From: Sarah Fawdry [REDACTED]
Sent: 02 March 2023 15:55
To: Jessica Riches; David Easton
Cc: Chris Brake; Katie Martin; Martin Kempshall; Thomas Richards; Silvie Steiningerova
Subject: Bilsham Road, Yapton - Y/70/22/DOC and Y/34/22/DOC
Attachments: 2023 02 08 Y 70 22 DOC Drainage Response.pdf; D1956-13-200B Proposed Levels Layout.pdf; D1956-13-201B Proposed Levels Layout.pdf; D1956-13-202B Proposed Levels Layout.pdf; D1956-13-300B Proposed Permeable Paving Formation Levels.pdf; D1956-13-301B Proposed Permeable Paving Formation Levels.pdf; D1956-13-302B Proposed Permeable Paving Formation Levels.pdf

Having recently picked up comments on your online portal regarding Y/70/22/DOC (dated 8 February 2023; attached for ease), please find our responses to the outstanding queries as follows. For ease and completeness, I have followed on from the previous queries with our responses, our latest response is detailed in green.

TABLE 1	
PIPE Ø (mm)	MIN. GRANULAR BED (mm)
150	150
225	150
300	150
375	150
450	150
525	150
600	150
750	150
900	150
1050	150
1200	150
1350	150
1500	150

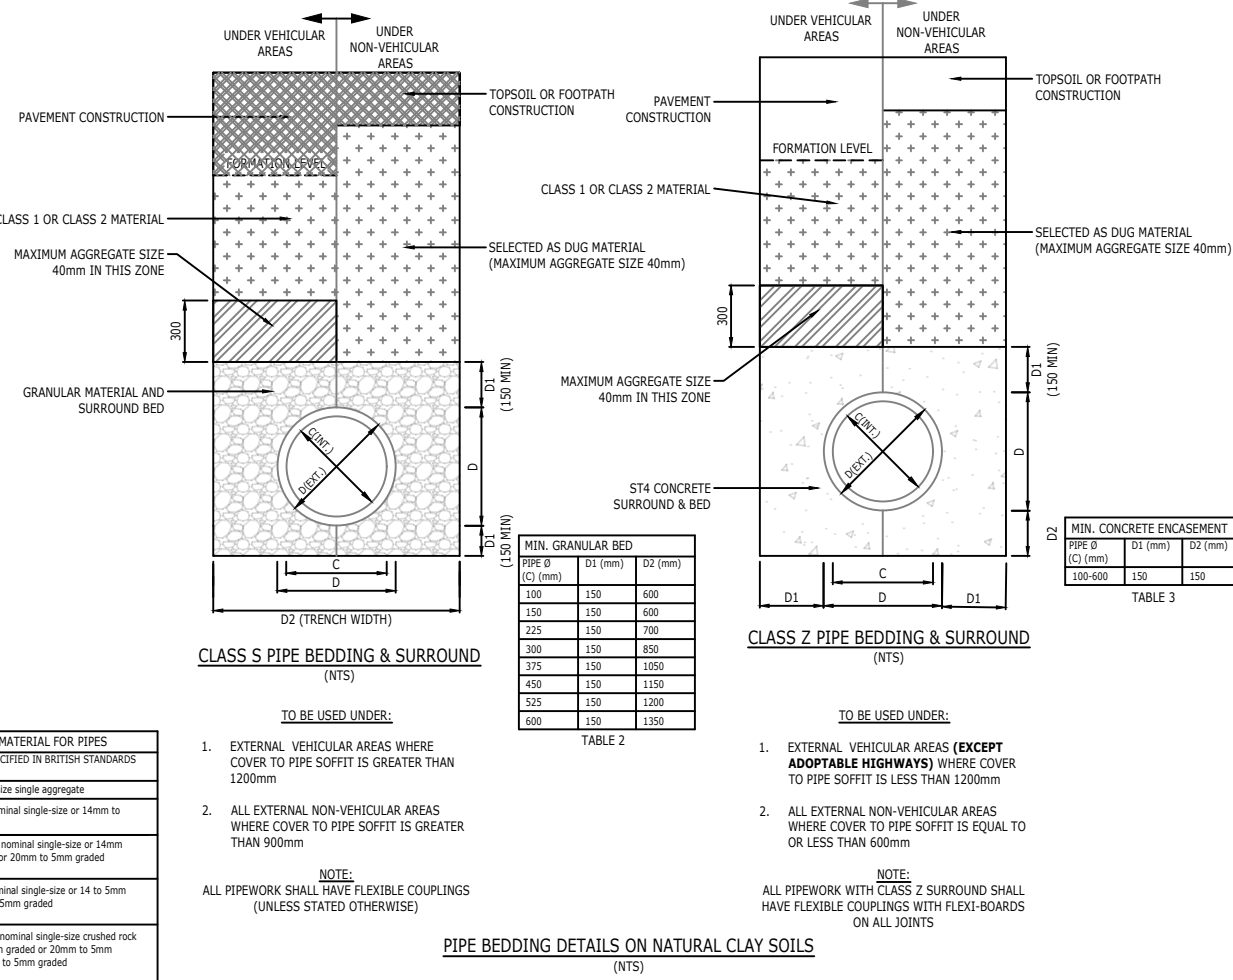
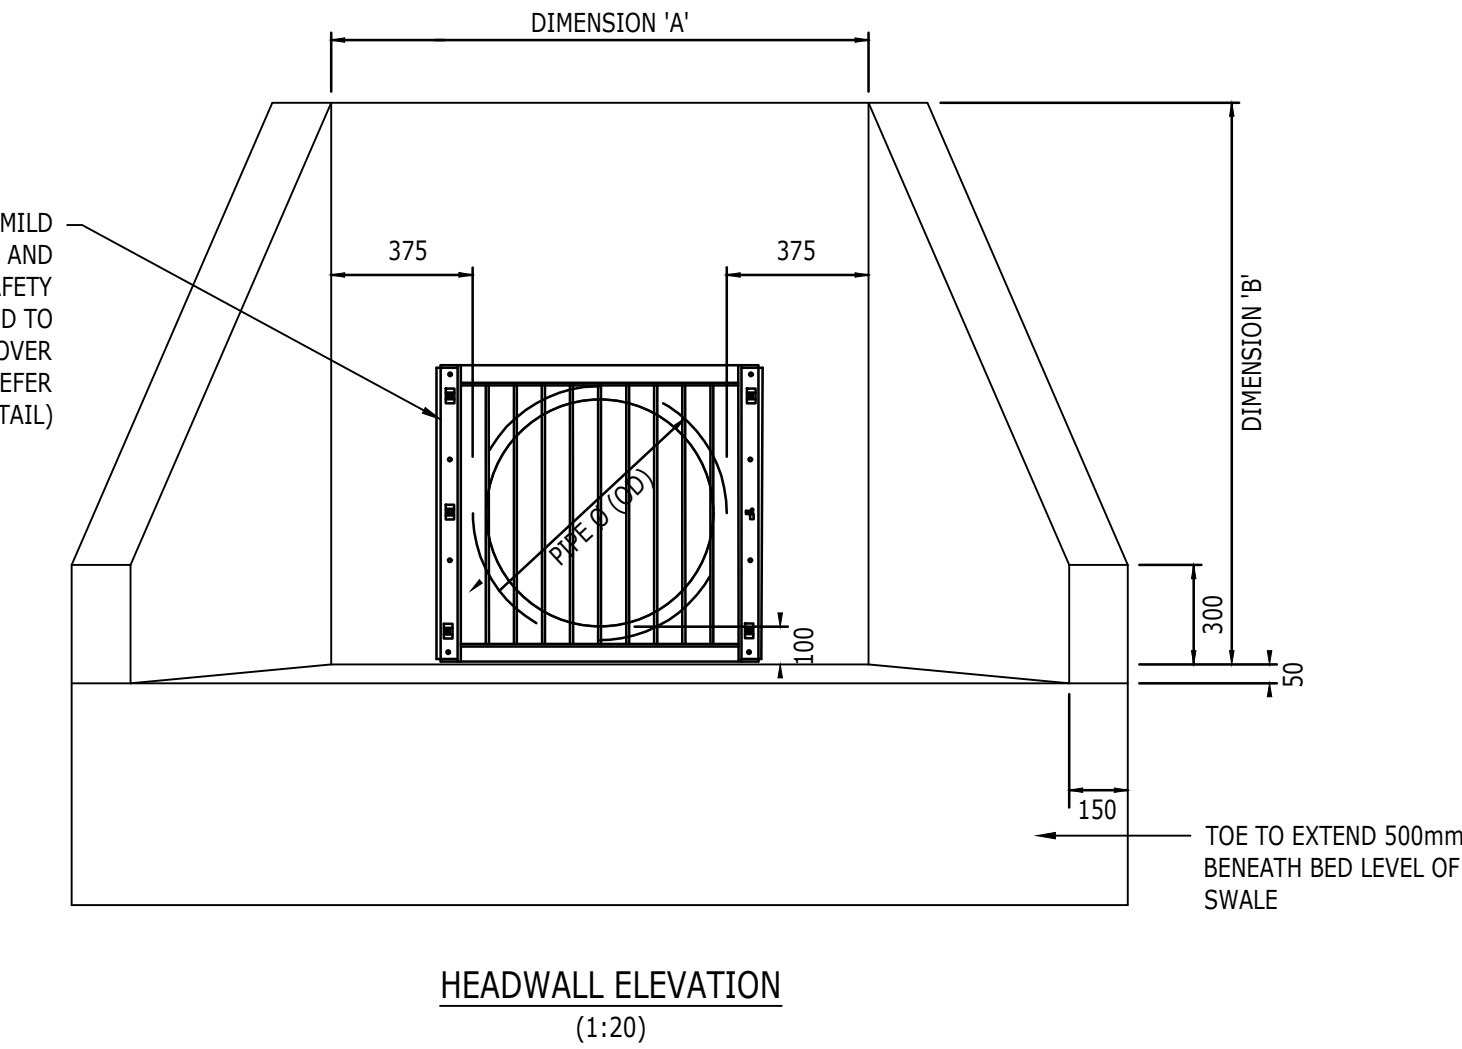
11. Please provide cranked grilles at a 45 degree angle. - Cranked grilles required on heads – S104 Construction details sheet 1 of 2 D1956-15-100 needs to be updated to suit ADC requirement. Pipe beddings details on this drawing are illegible in parts. Information needs to be clearly presented. We note that applicant's response that this is not "DSG compliant" however the drawings refer to Sewers for Adoption 7th Edition. As such the applicant needs to be clear which edition of Sewer for Adoption the adoptable drainage is being designed to. In addition they should confirm who the adopting authority will be as well as confirmation from the adopting authority on whether they will or will not accept cranked grilles. 08/02/2023- Whilst it is noted that the Technical Approval certificate has been provided for information, this doesn't clarify whether the adopting authority has considered a request to use cranked grilles. This needs to be confirmed by the adopting authority otherwise cranked grilles should be used TH: There is no provision in DCG for the use of cranked grilles, only grilles installed flat against the headwall. In addition, we consider that cranked grilles create a health and safety issue as they could encourage people to climb up on them up to a perch from which people could fall.
